From: Laura Gibbons
Sent: 03 May 2019 16:02
To: Simon Davis <Simon.Davis@arun.gov.uk>
Subject: RE: Y/9818/RES and Y/97/18/DOC

Still not happy with the details or the proposed landscaping details. My original comments are shown in blue, the applicants responses are provided in red, and my responses to these are shown in *purple*:

drawing no: BOV22172 12F sheet 4

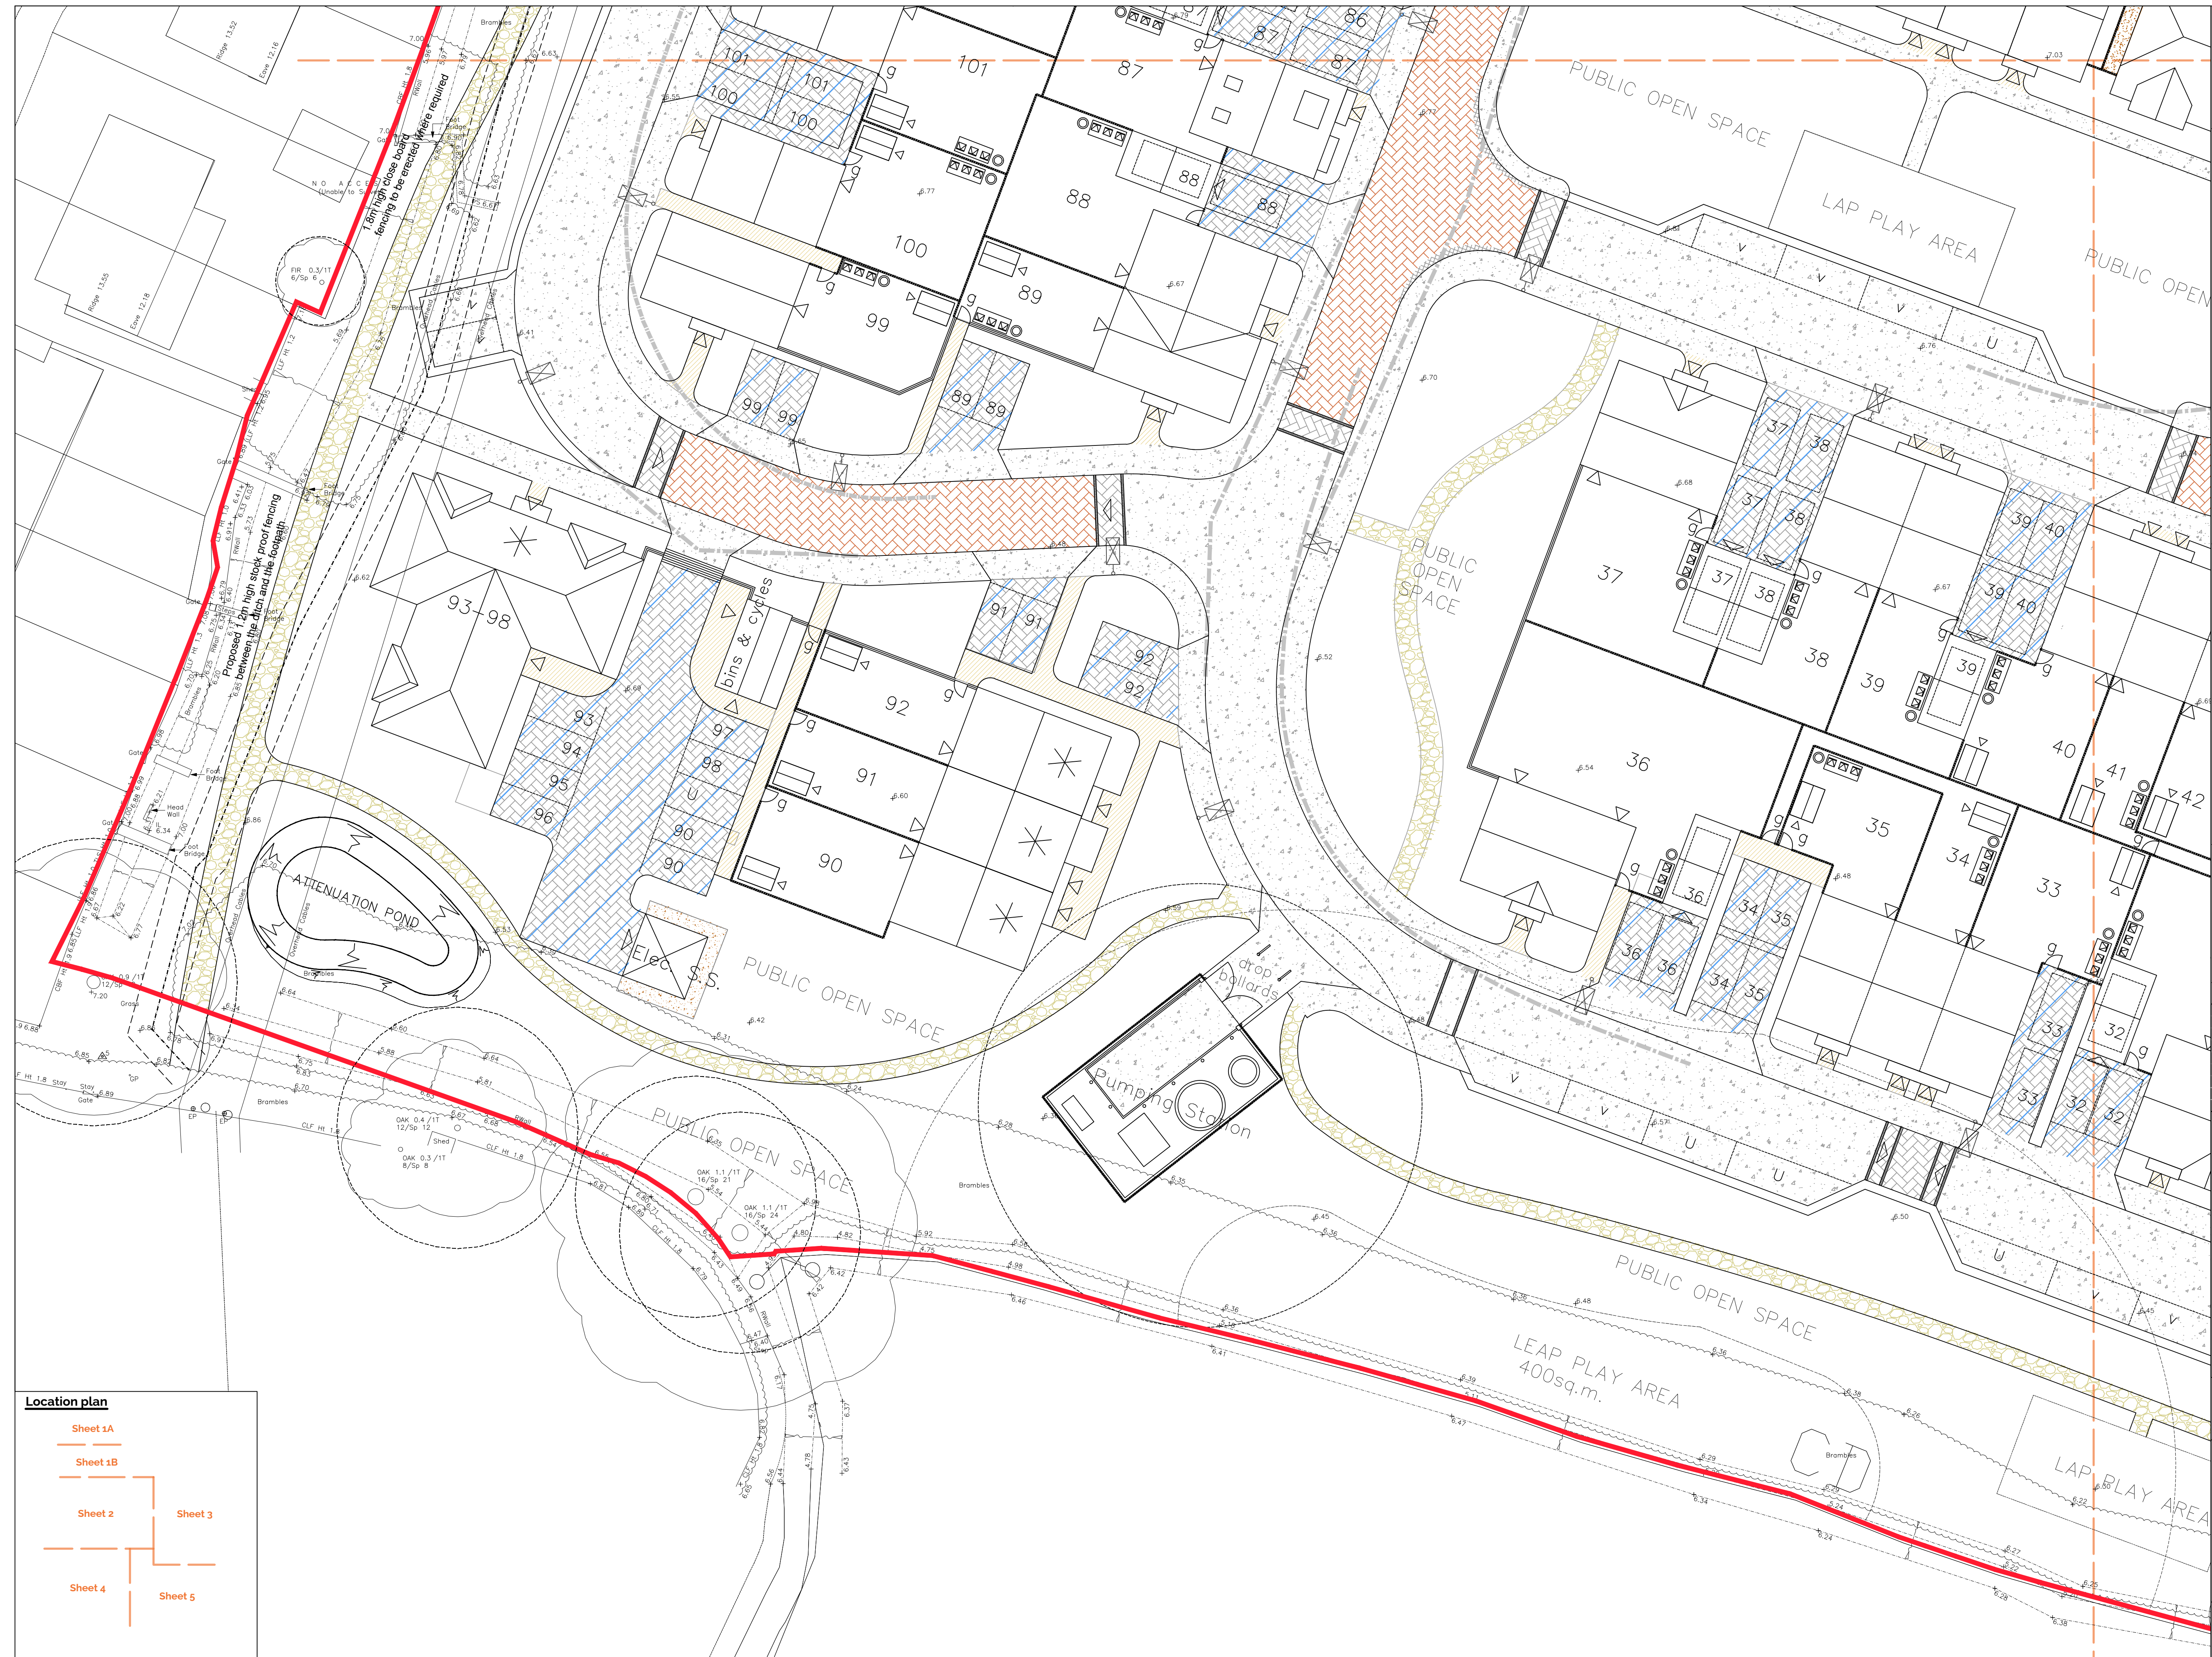
1. There are still trees proposed in close proximity to the southern-most attenuation tank. 2 no. trees close to this tank have been removed. Refer to updated ACD landscaping drawings. *On the ACD landscape drawing sheet 4 revision G there are trees in close proximity to the crate nearest the pumping station. Please can a plan be provided which shows both the proposed drainage and the proposed planting and associated potential root areas on the same drawing.*
